Response to Adult Care Homes comments:

TITLE  
 Proposed Site Sections Sheet 1

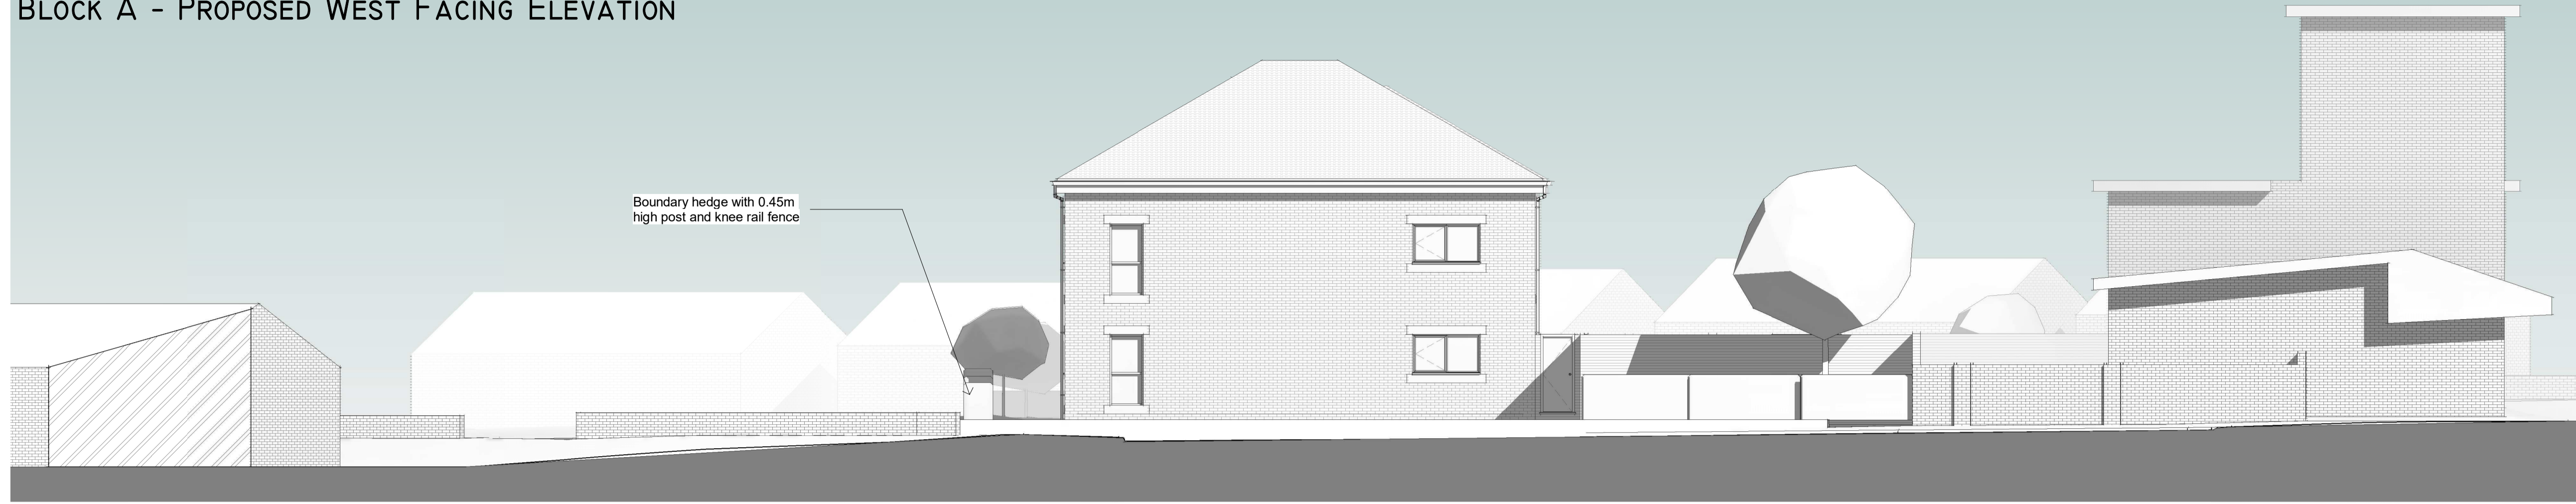
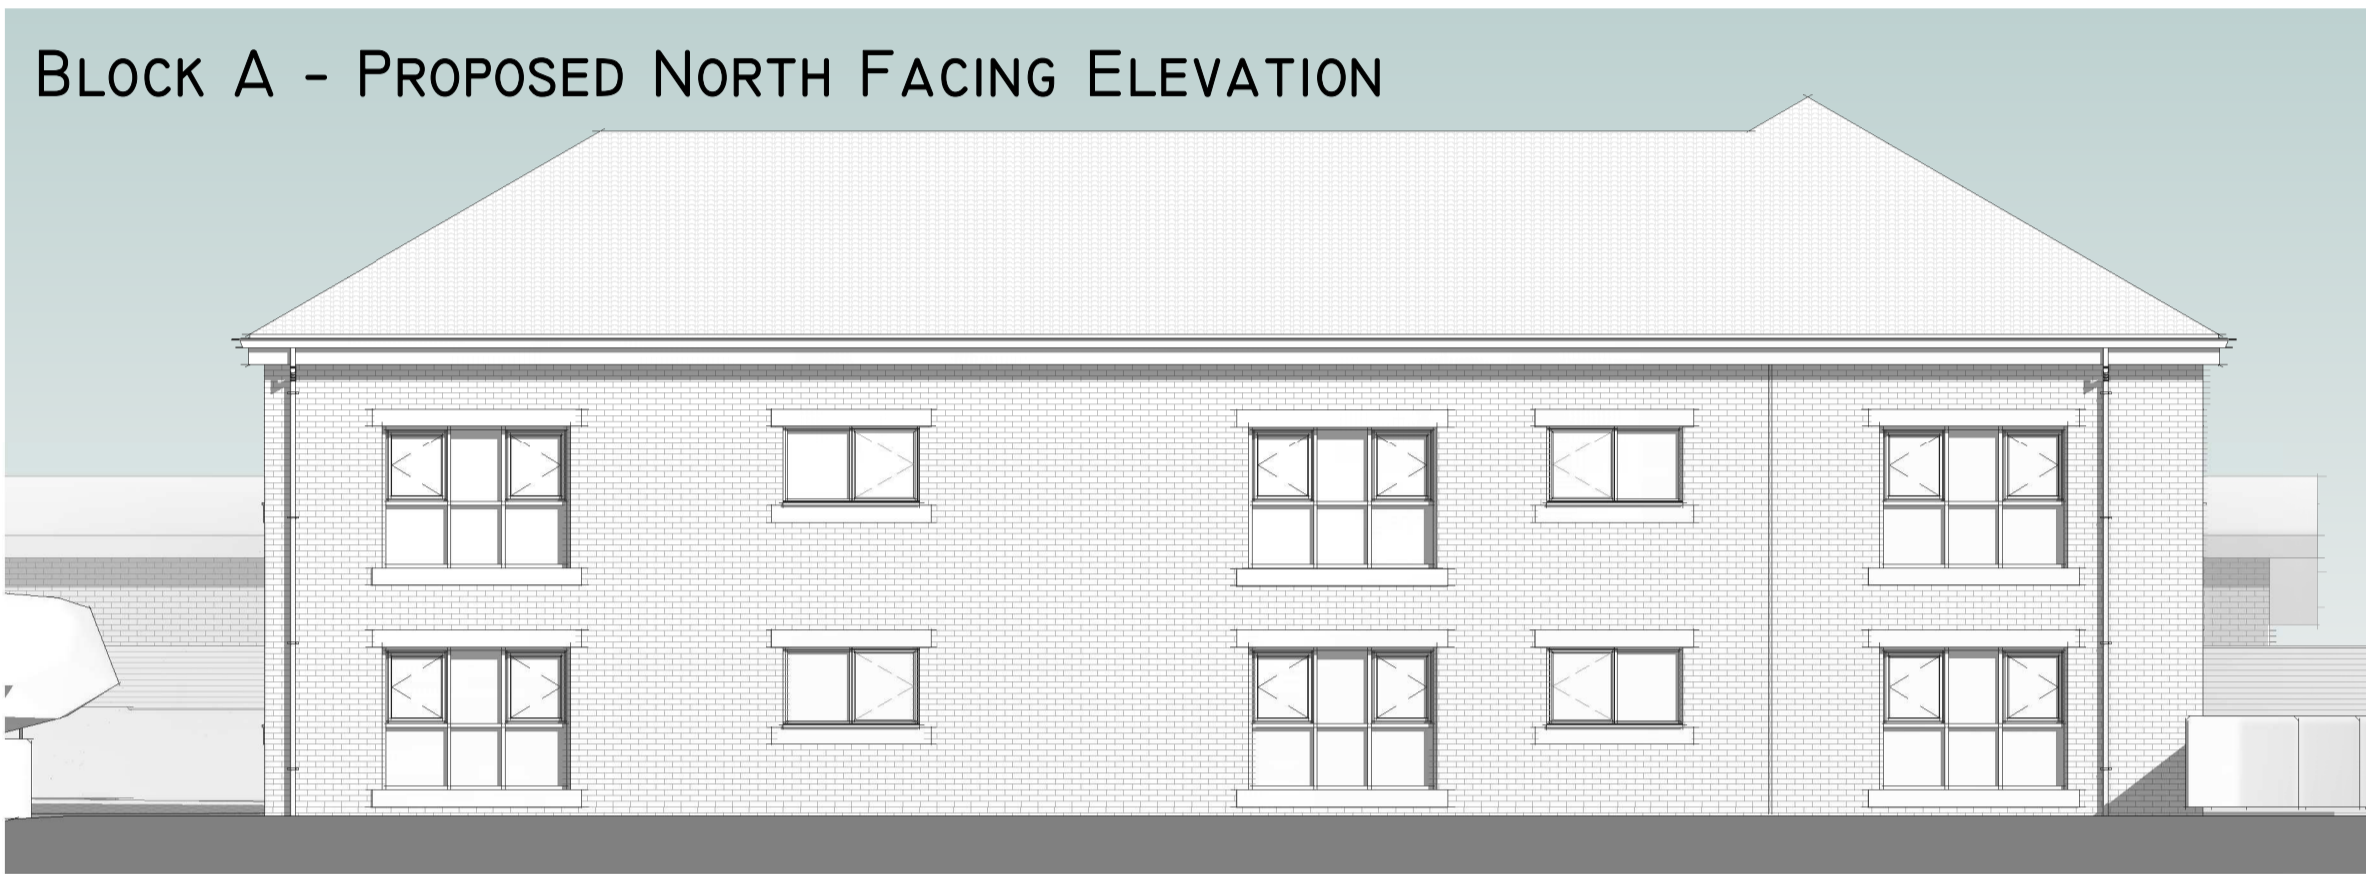
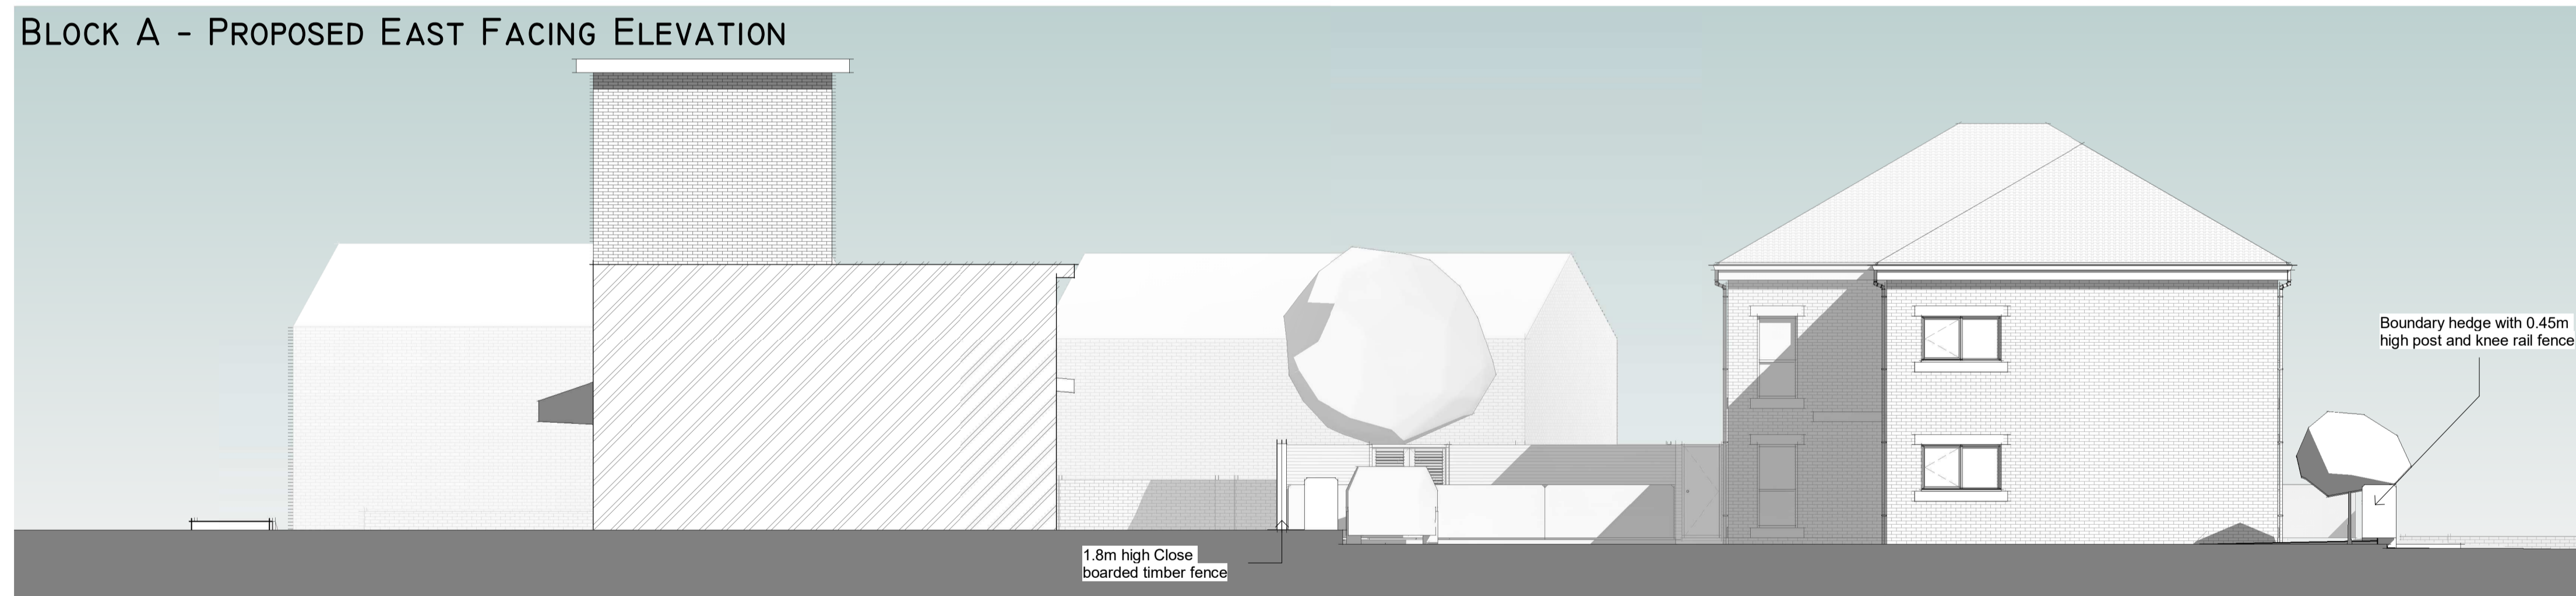
The drawings are taken from a 3d model so the items shown on the section drawings are correct.

PROPOSED SITE PLAN
SCALE 1 : 200

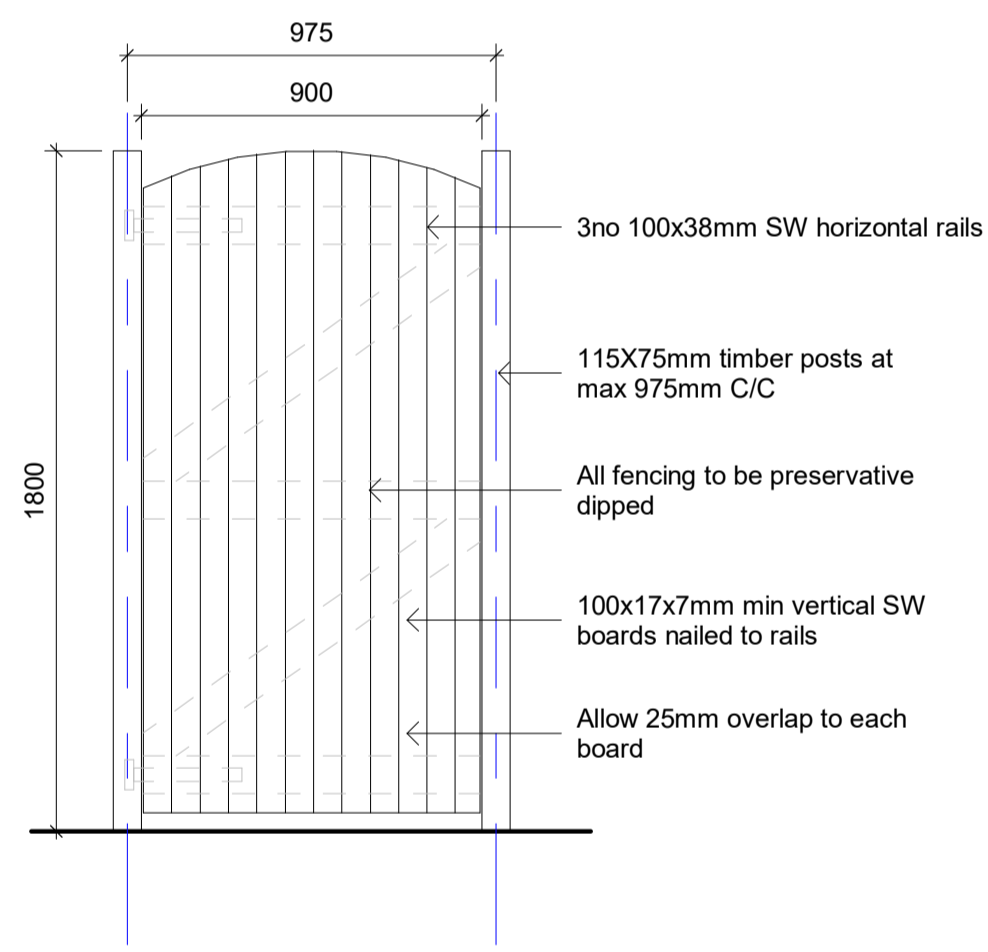
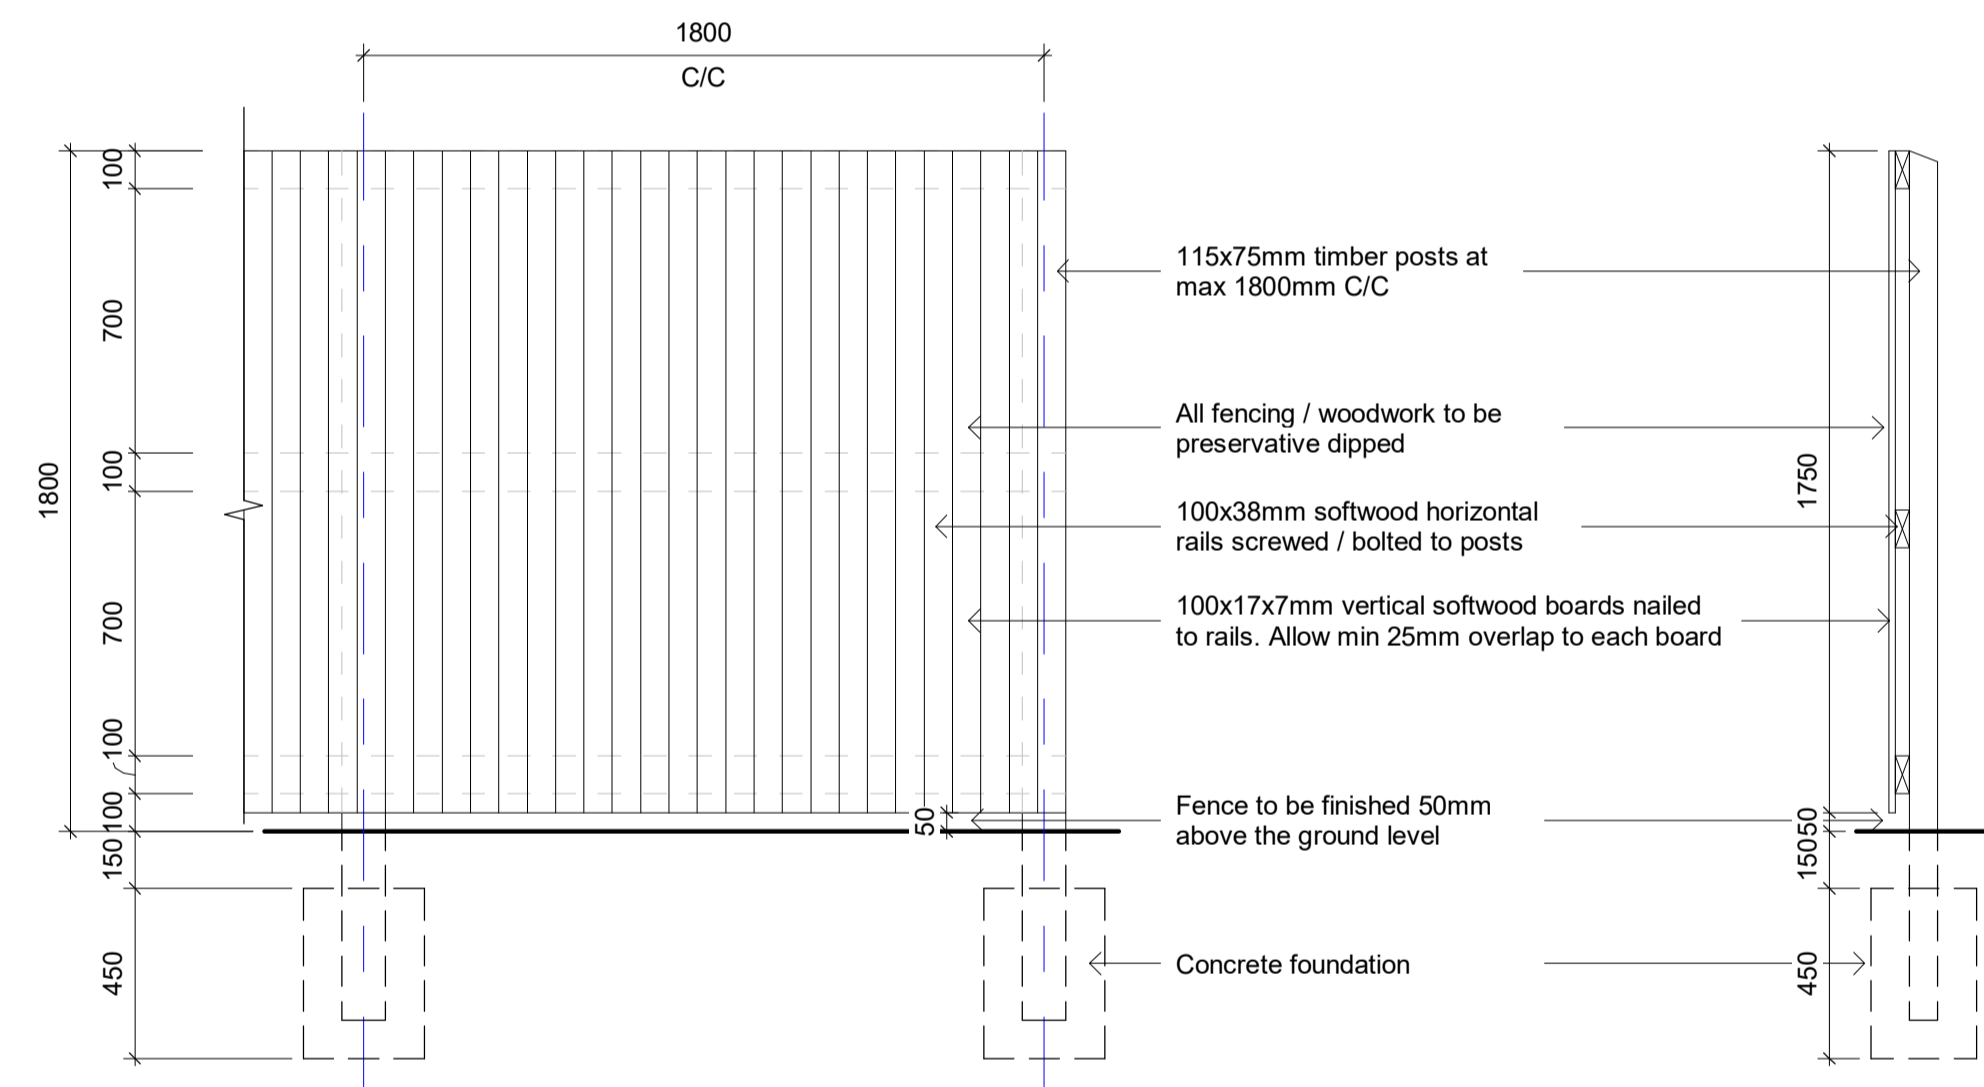
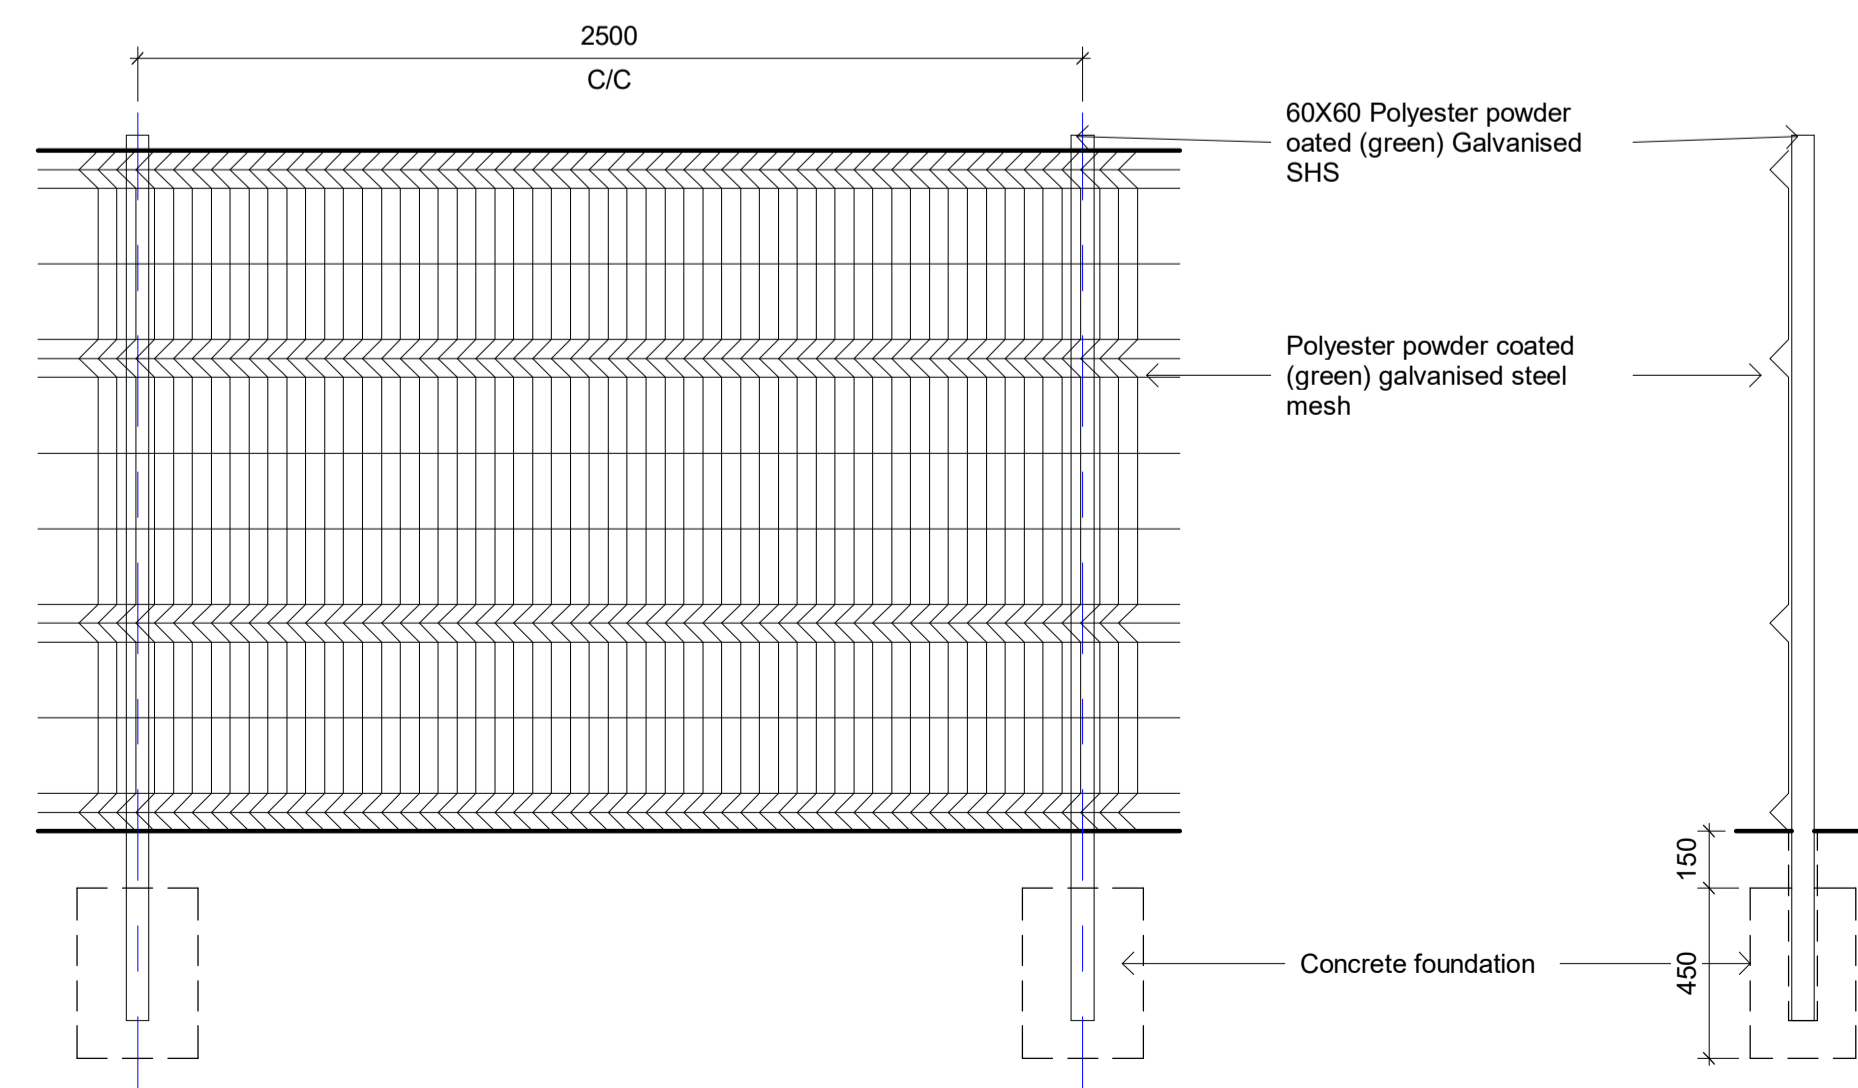
The northern boundary was intended to be low level planting and boundary treatment to allow better views and natural light into the apartments along that boundary, we are happy to install more secure fencing along that boundary but feel that Palladin fencing rather than Palisade fencing would be preferable.
